Technical Note 002		
Project Name and number:	Church Road, Climping	D2385
Subject:	SW Drainage Planning Conditions	
Client:	Foreman Homes	
Prepared by and Date:	LF	21/10/2025 (Rev 0)

Response to Arun District Councils comments dated 06/08/25 relating to Planning Condition 9 attached to Decision Notice Ref: CM/18/25/DOC.

Drawing Title **Domestic Drainage Layout**
Sheet 8 of 22

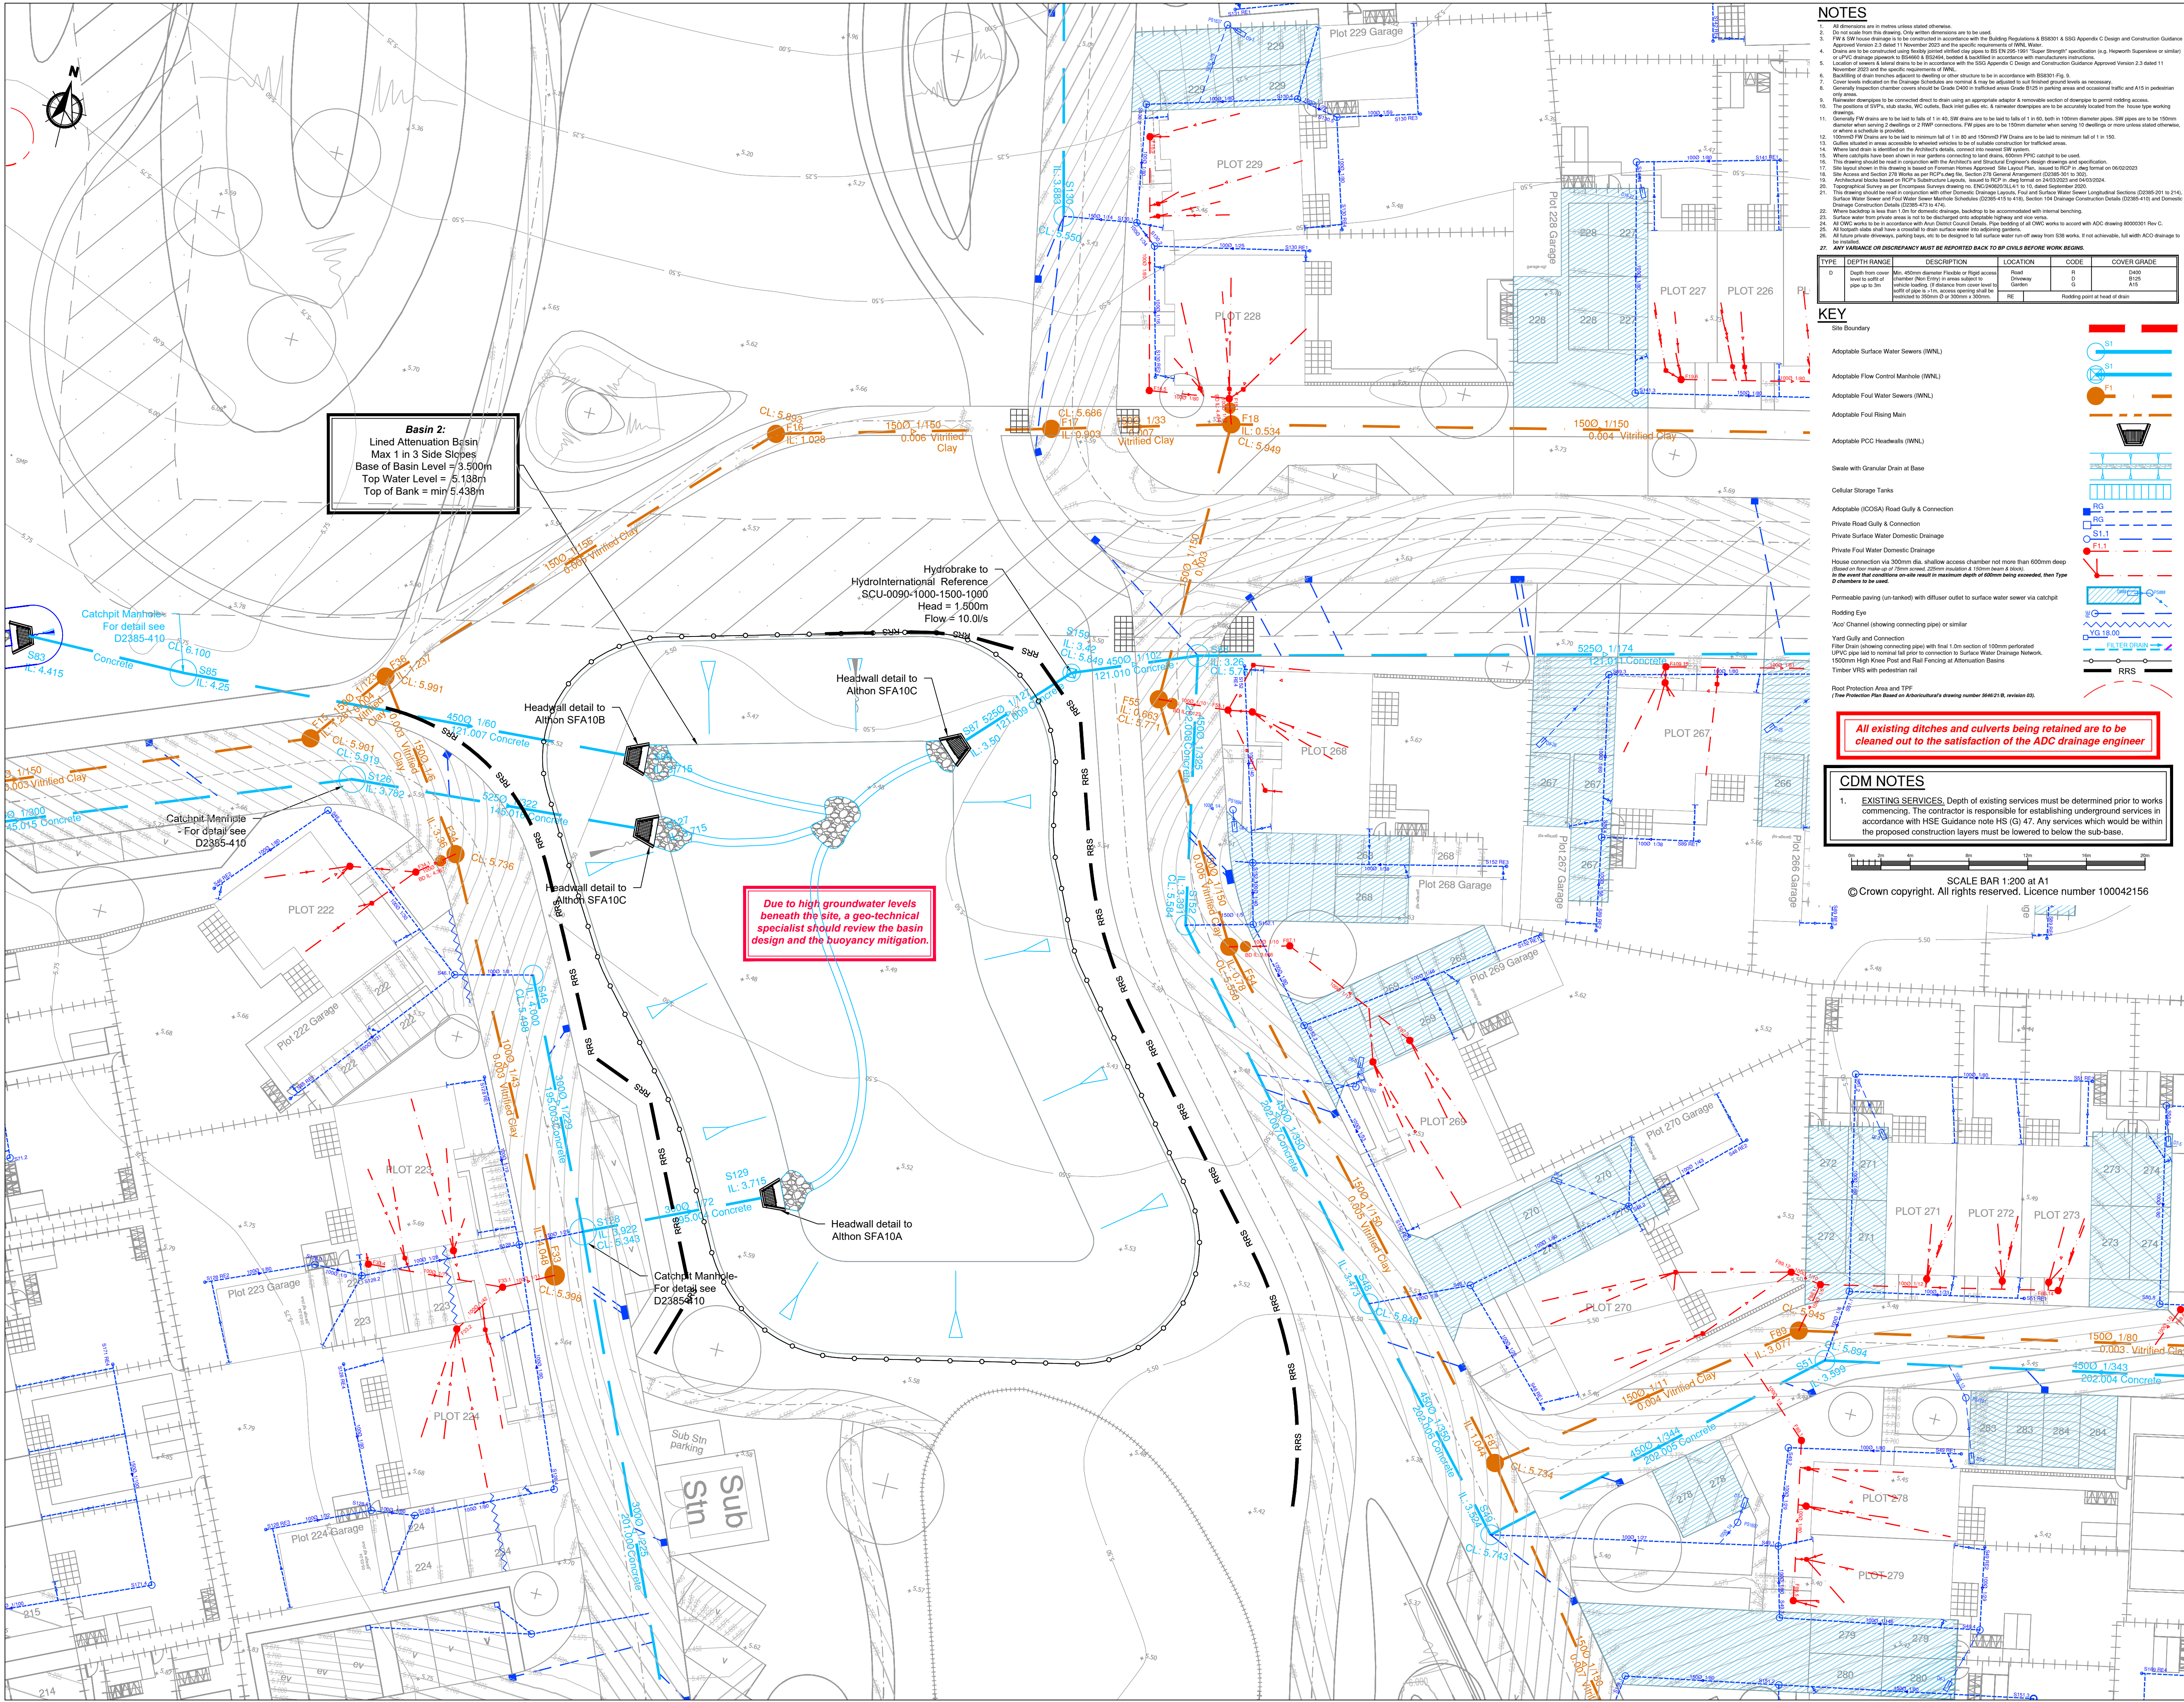
The gullies outside plot 268 should be moved slightly to the lowest local point.

The gullies have been moved to the correct location. Please see drawing referenced 000-BPC-ZZ-D-C/D458, included in this resubmission pack
